# Rezoning Transportation Analysis

Petition Number: 2021-186

Date	Description
12-28-21	First Review (TNM)
01-27-22	Second Review (PDM)
02-24-22	Third Review (TNM)

REZONING - SITE PLAN
THE VILLAGES AT GOVERNOR HUNT
9405 MALLARD CREEK RD., CHARLOTTE, NC

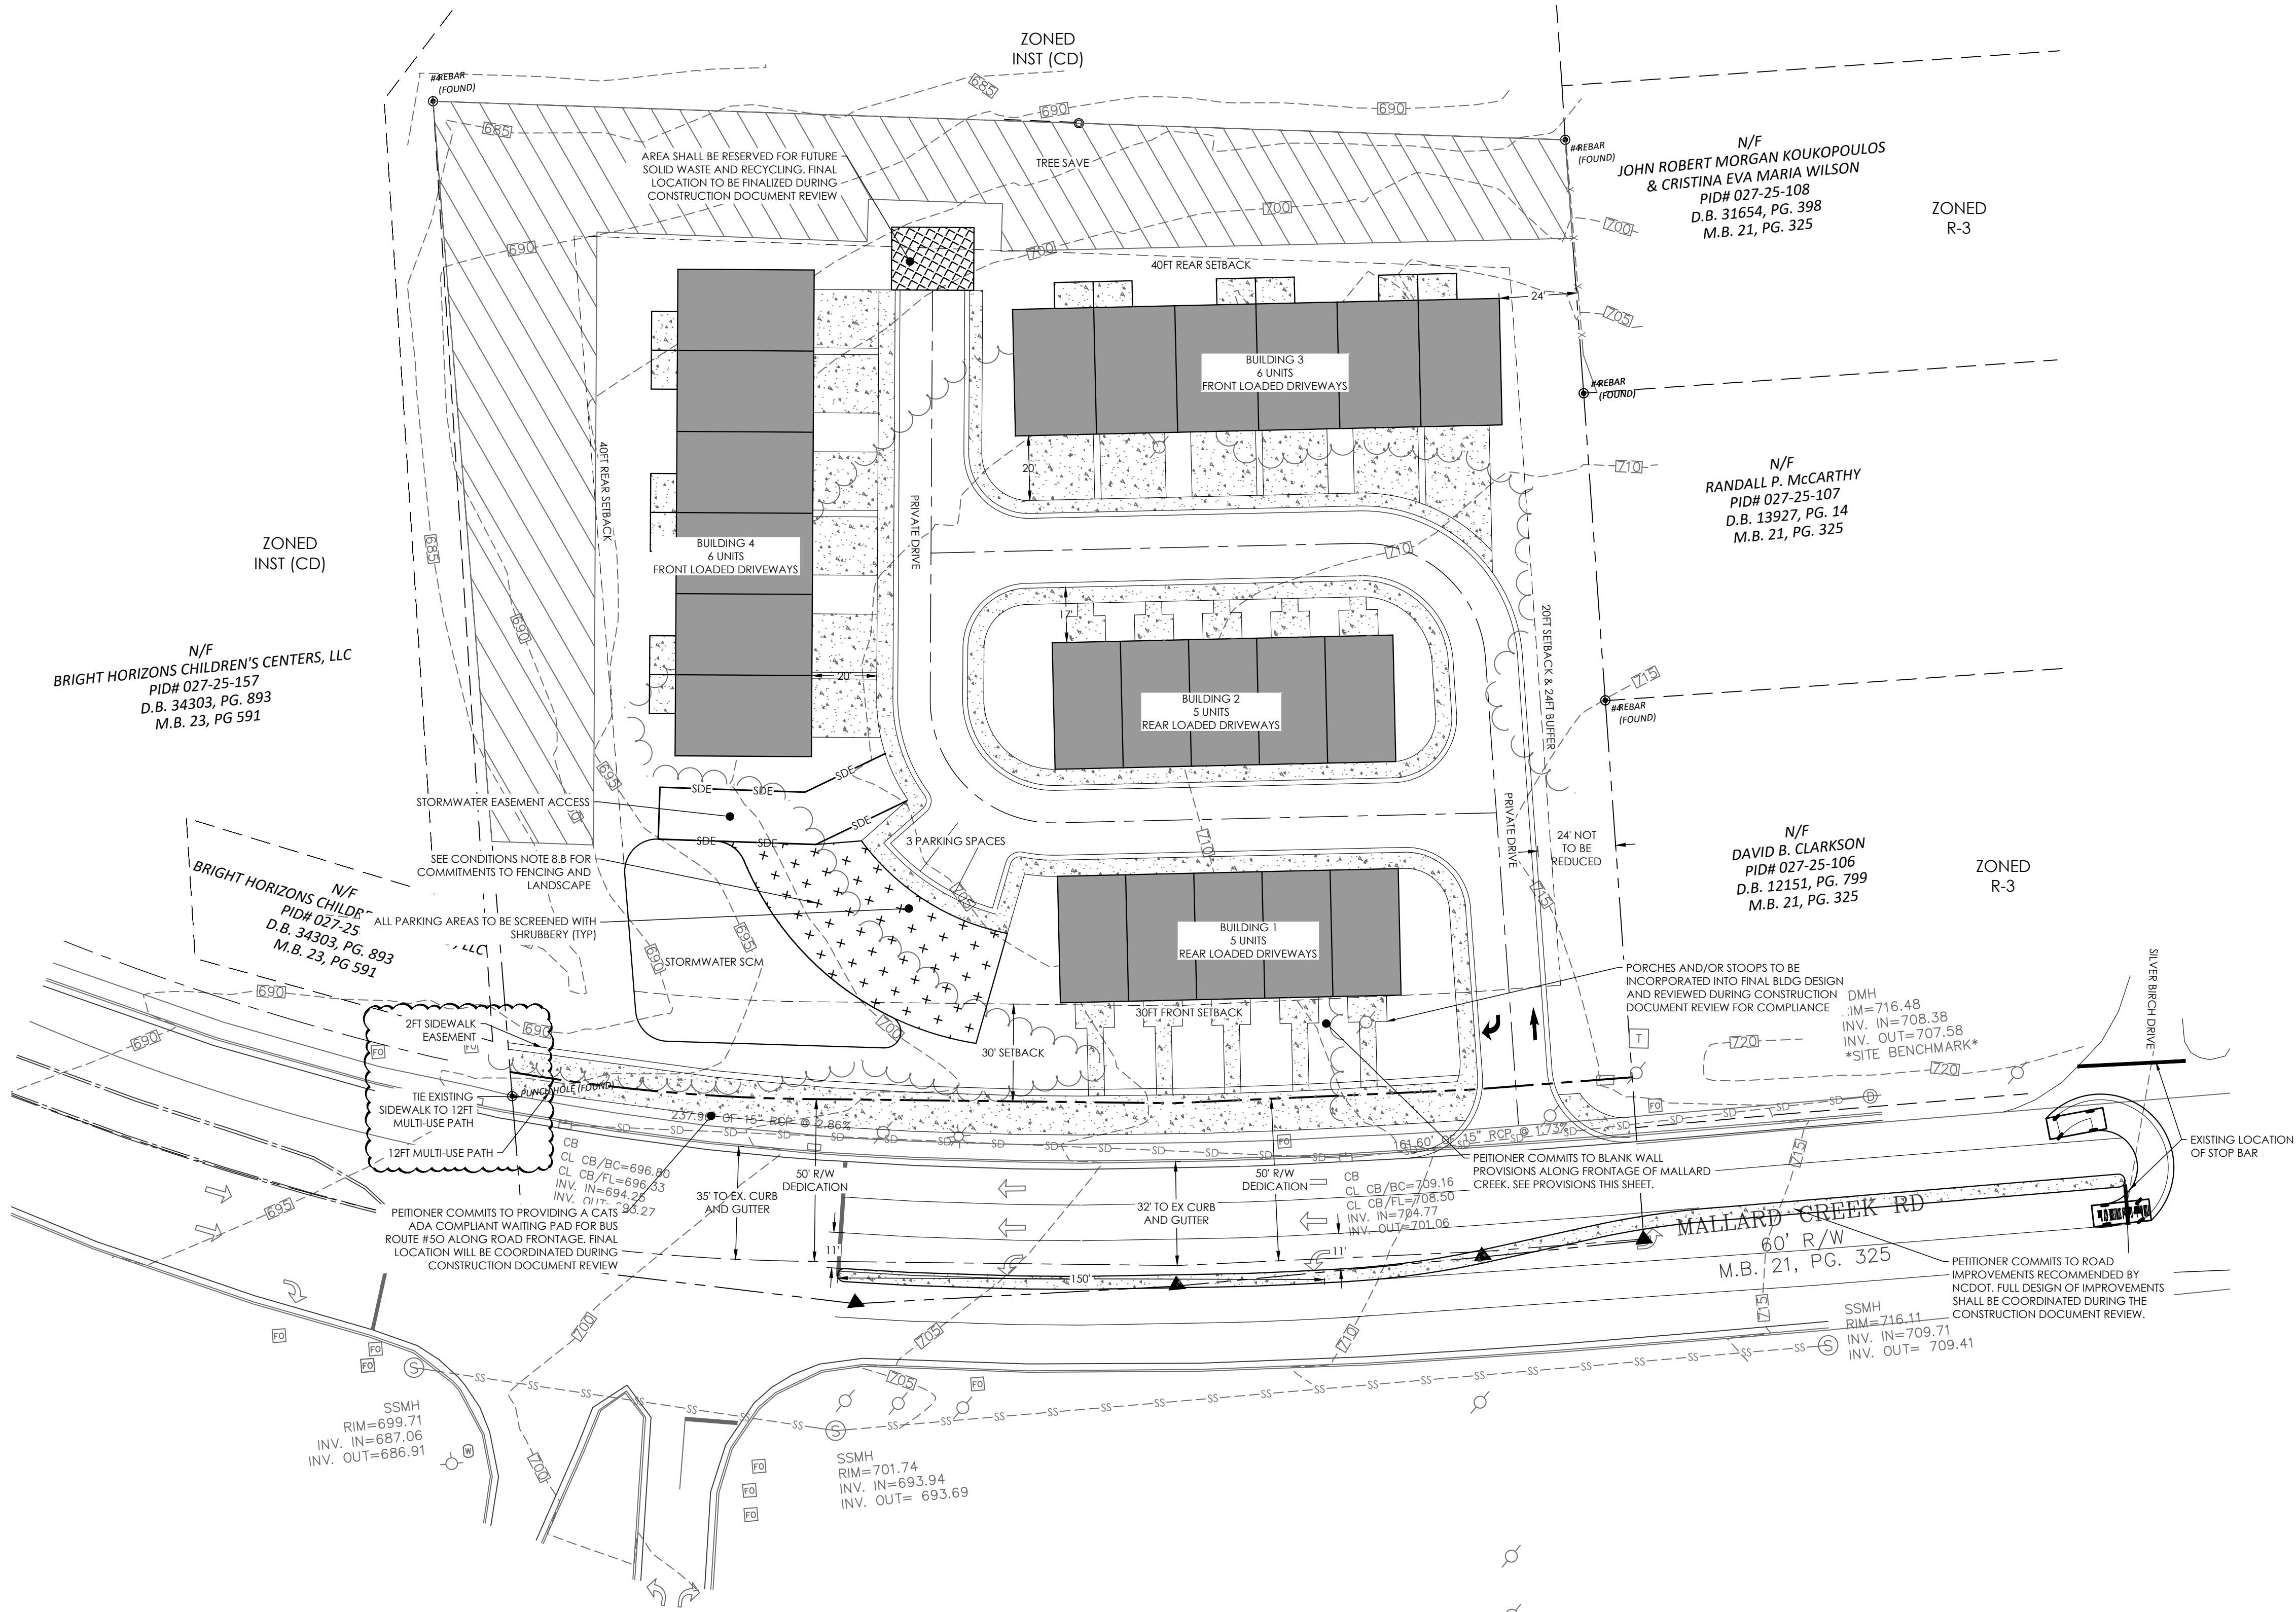
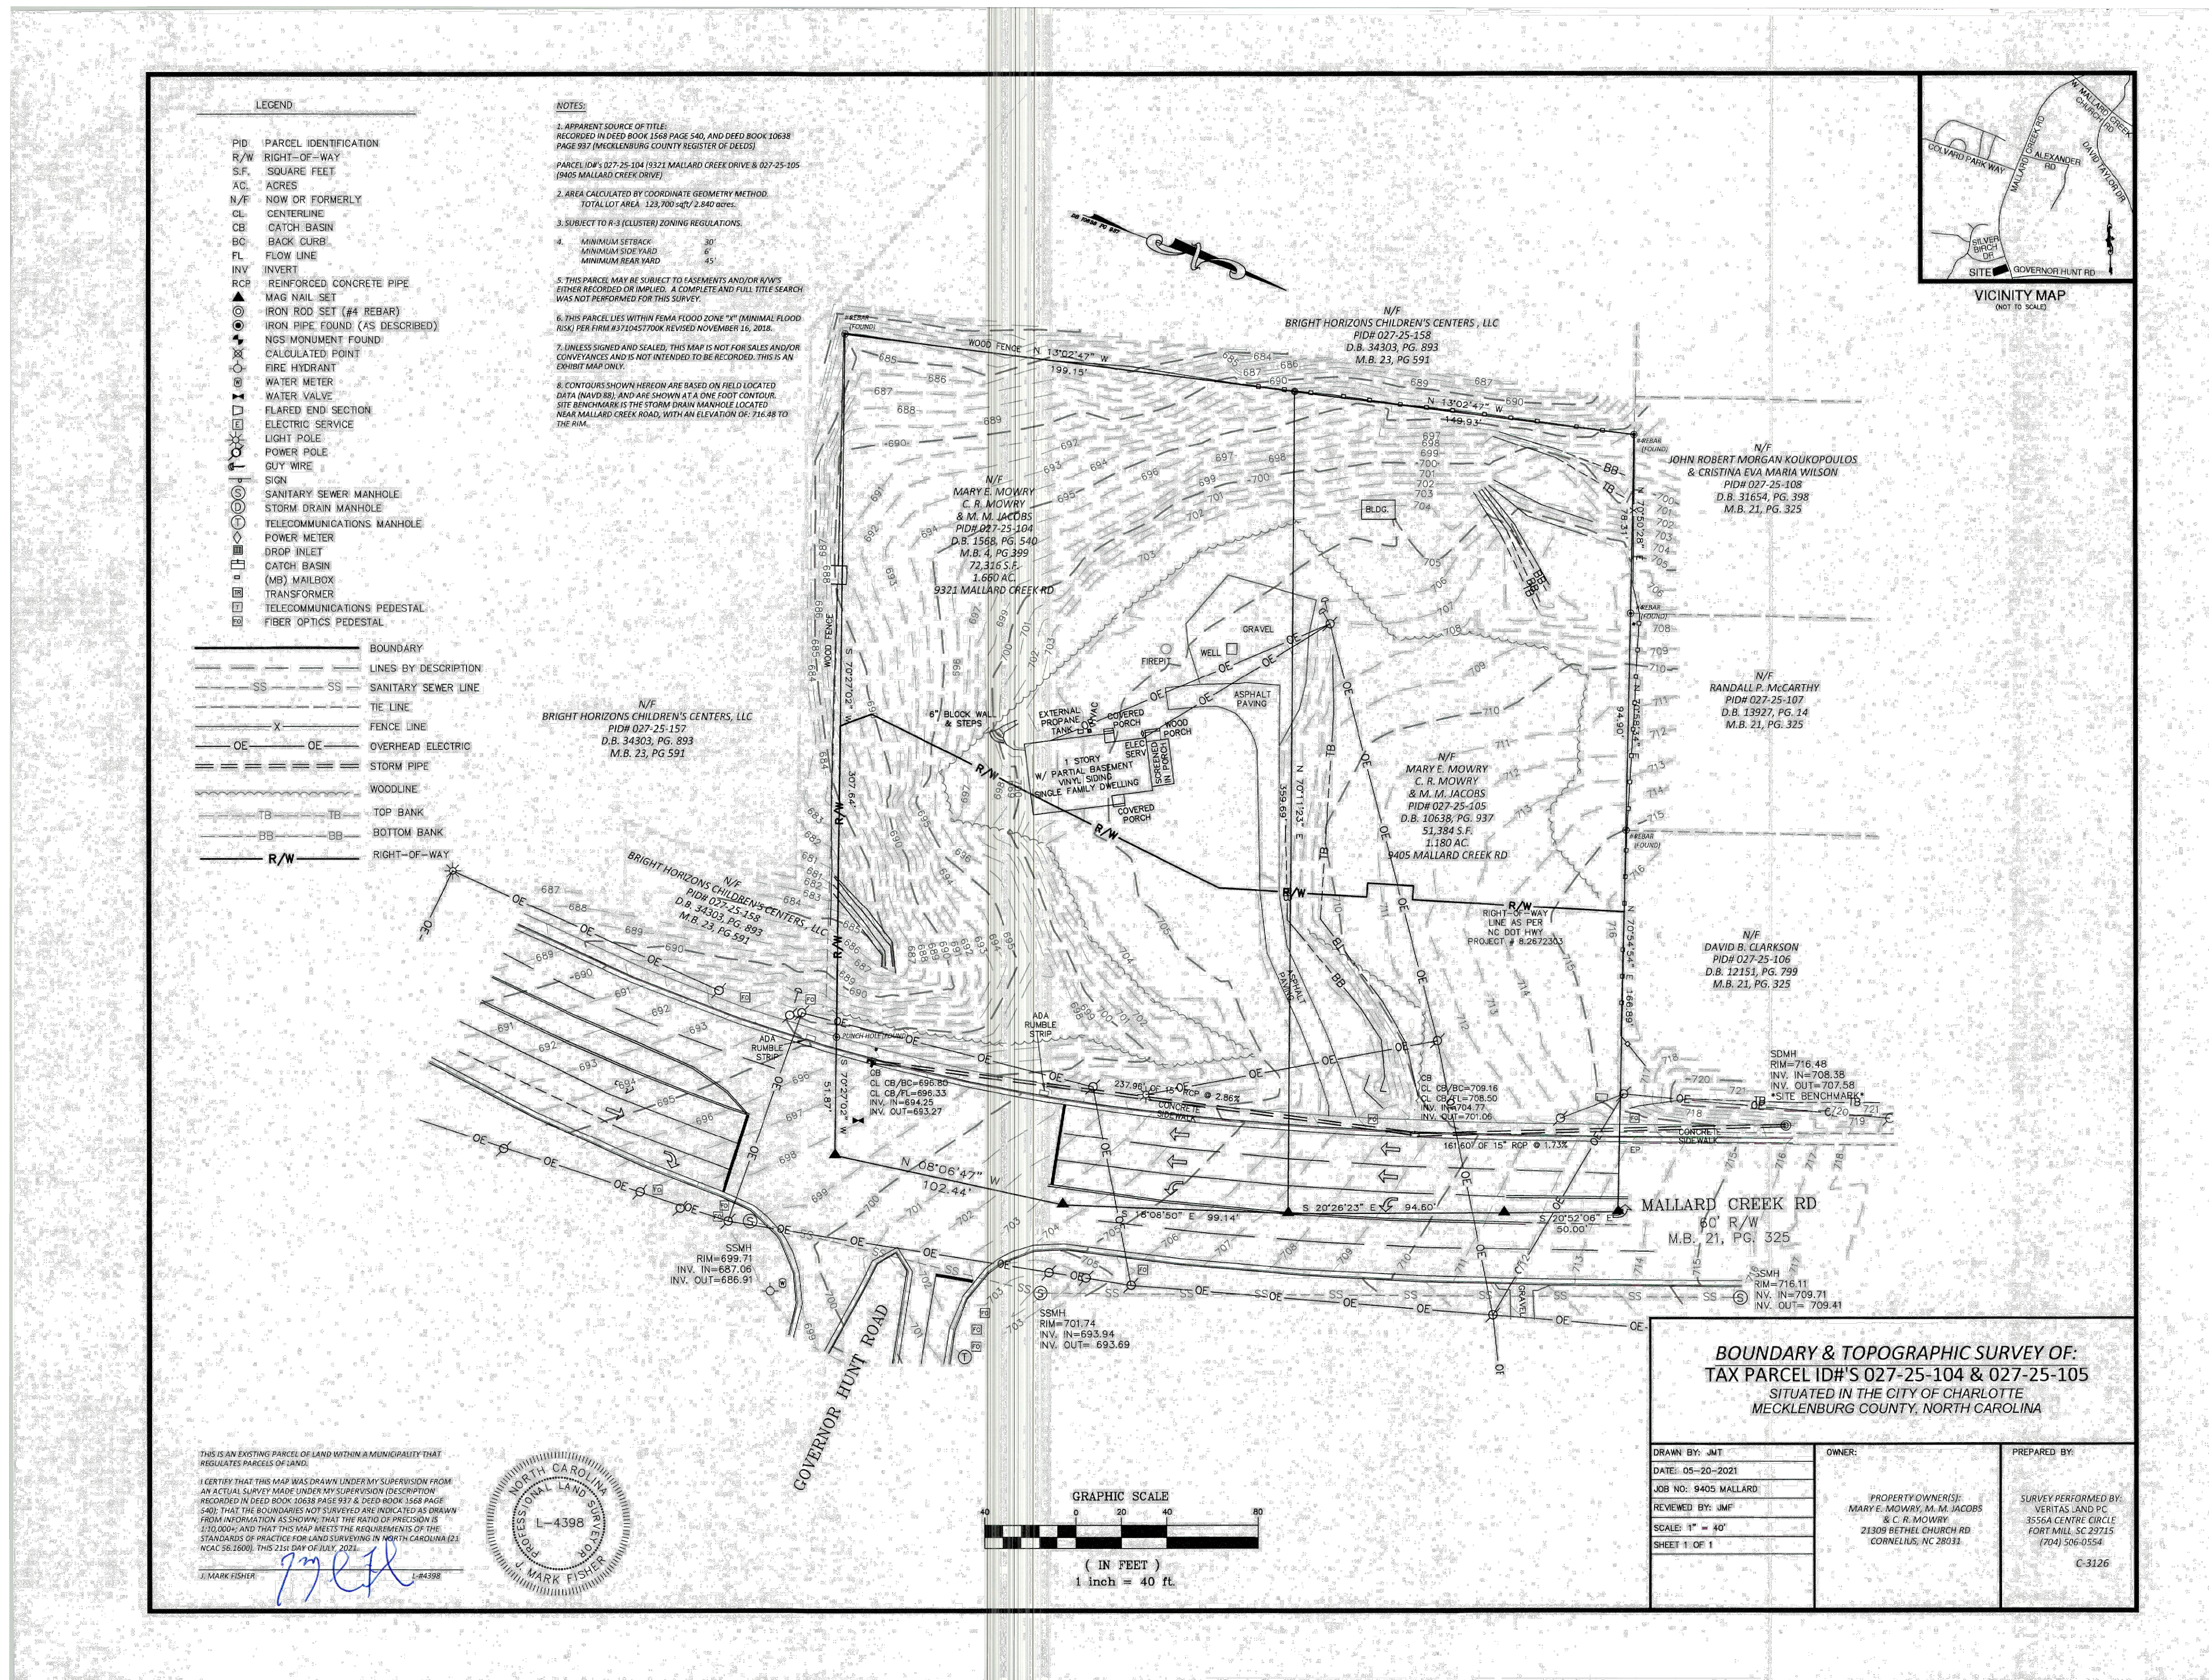
**Outstanding Comment from 01.27.2022:** Label and dimension the curb and gutter from the centerline for each road on the site plan.

**Clarifying Comment from 01.27.2022:** Median needs to be designed to allow for a minimum of 150ft of full width storage for the Mallard Creek left turn lane at Governor Hunt. Show 150ft of full width (11ft) storage. A conditional note specifying the requirement of the 150ft of full width storage and the concrete median should be added to provide clarification.

**Clarifying Comment from 01.27.2022:** Driveway radius needs to tie into the curb line at a tangent.

- 11. Outstanding Comment from 02.24.2022:** Proposed 12-ft multi-use path along Mallard Creek Rd should extend the entire property frontage per Ch 19. SUE is required 2ft behind multi-use path if located outside of the 50ft dedicated ROW for future maintenance.

**Clarifying Comment from 02.24.2022:** CDOT requests a 12ft multi-use path along Mallard Creek Rd. The 6-ft sidewalk as proposed is required per Chapter 19. The wider sidewalk is in conformance with the Charlotte WALKS and BIKES policy. Revise the site plan to show sidewalk utility easement 2-ft behind the sidewalk if located outside of the ROW. Site plan revisions are also required to show the sidewalk tie in at the property line. Add a conditional note committing to the 8-ft planting strip and 6-ft sidewalk.
